From: Emma Bateson <[REDACTED]>
Sent: 21 March 2024 10:19
To: Tree Service
Subject: Re: -23/00264/TRTPO Mornington House

Is the picture in the Arboricultural Assessment (Fig 1: Proposed pruning to top branch of pine tree #02) how you intend to prune the pine?

DWG Ref: MW.21.0809.TPP.RevA

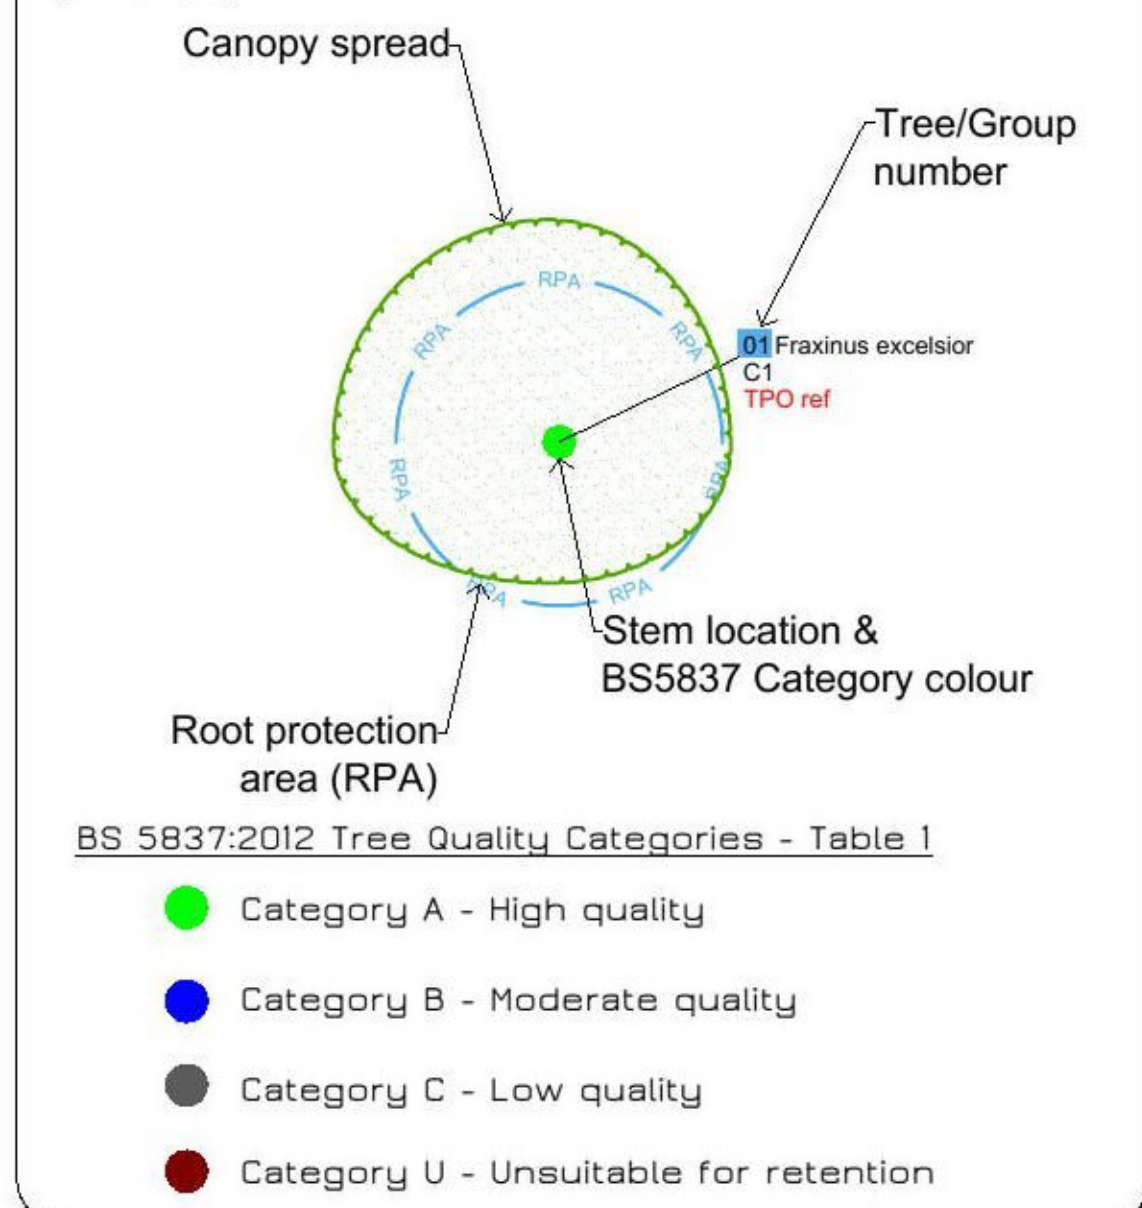
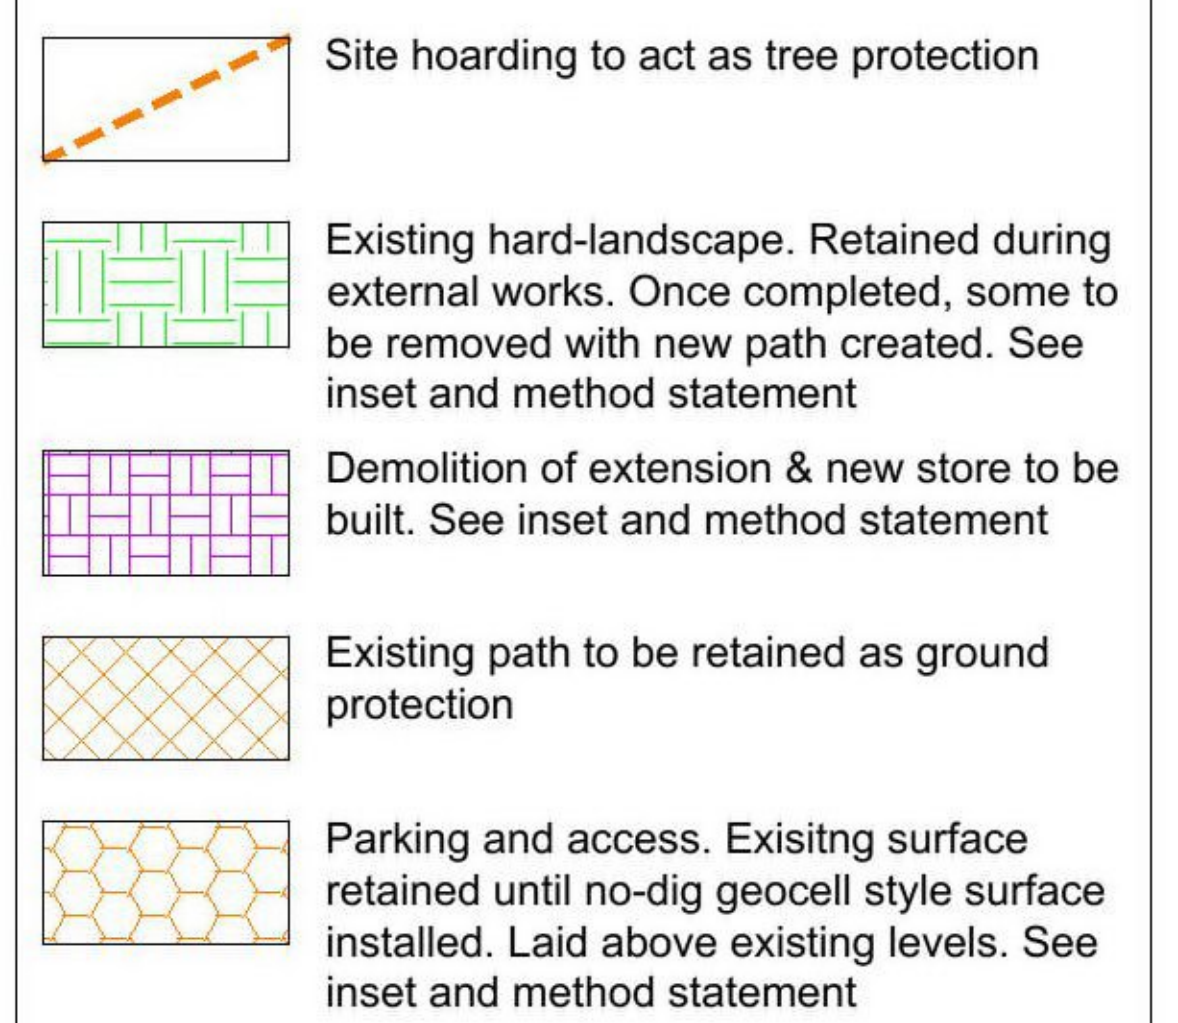
I need more detail than “a little lateral pruning”. The description I usually send is below, essentially, how far away from the house will the end of the pruned branches be please?

Selective Crown Reduction - The location of that part of the crown should be described and the amount of the reduction proposed should be stated in terms of the intended remaining length of the limb/branch after pruning or by the proposed distance between any structure and the end of the pruned branch.

The application asks to "trim and reduce height above ground level to provide sufficient clearance to new property." If you are just raising the canopy could you tell me by how much please?

The pine tree currently touches the house. We would like to prune lateral branches so it is 2.2m away from house. This leaves a branch length of 4.8m
We want to remove the odd growing branch as highlighted in the report shared
Canopy lift to 4.8m

For the neighbours tree
Canopy lift to 4.8m

Branches touching house so prune lateral so 3m away from house. This leaves a branch length of various length as many branches (2-5m)
